# SCHMIDT PARCEL REZONE MULTI-DWELLING

REZONE EXHIBIT

# V2\_Zoning Map.pdf Markup Summary 2-6-2023

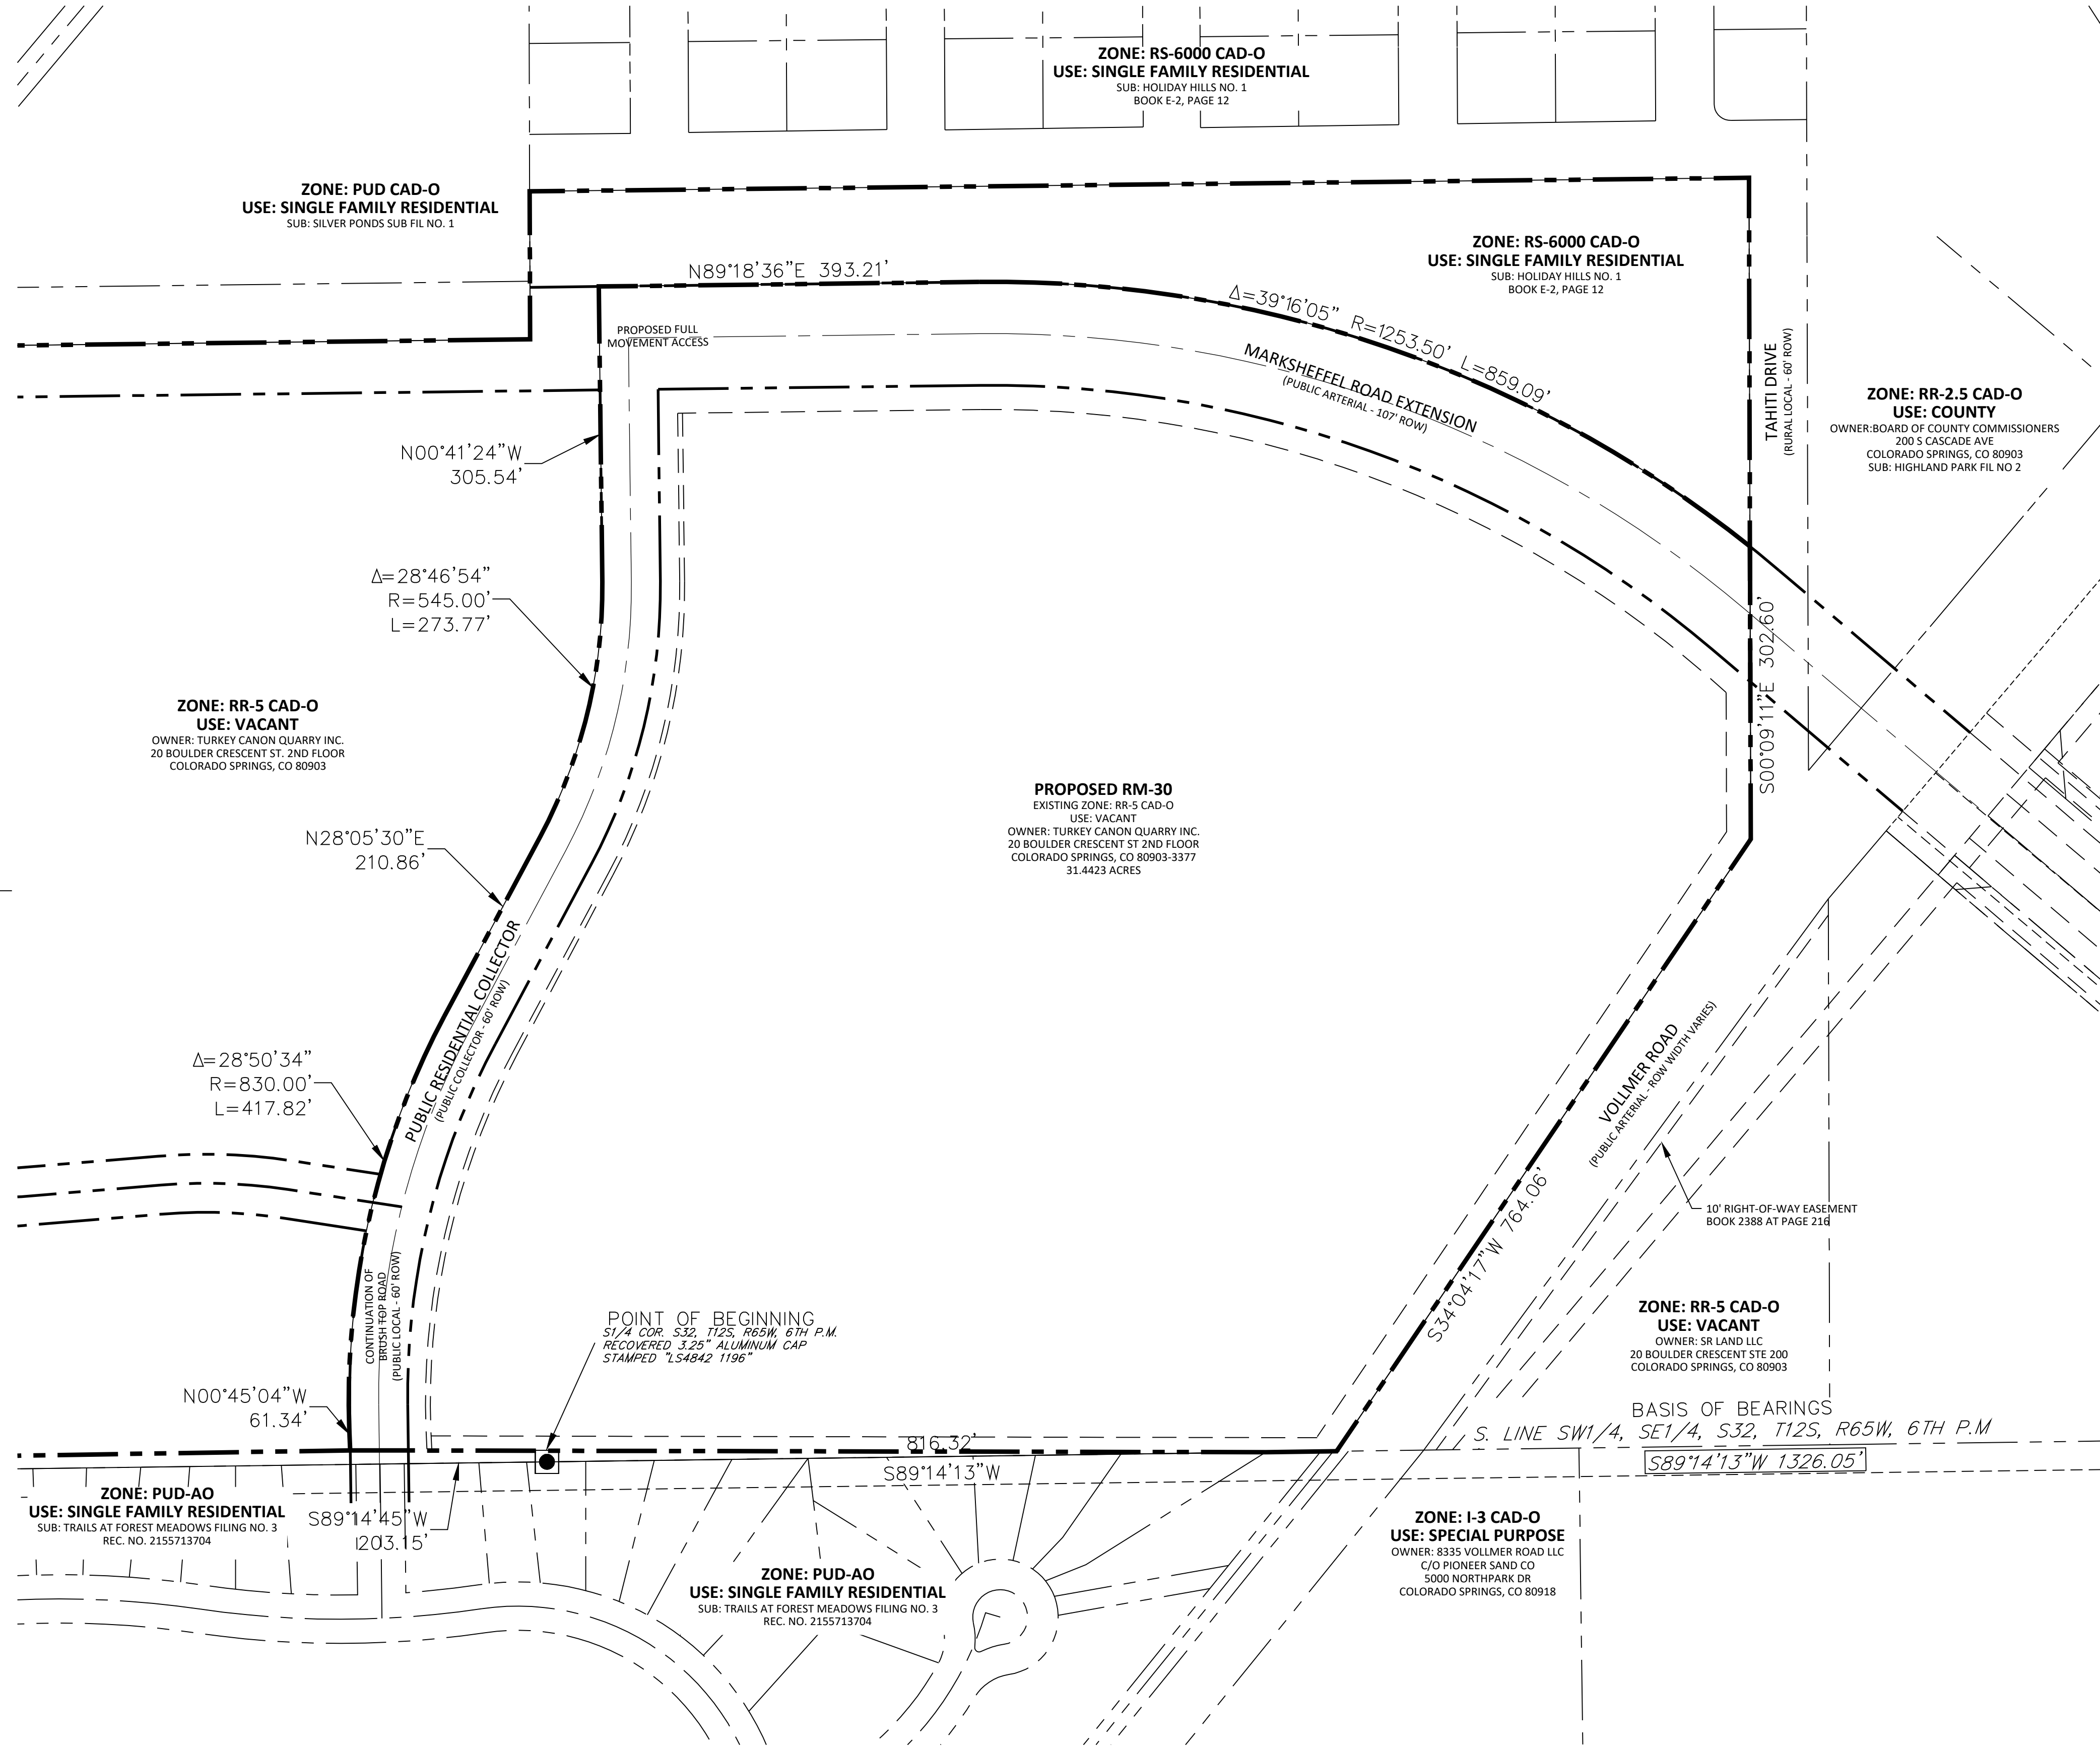
Replace Local with Collector
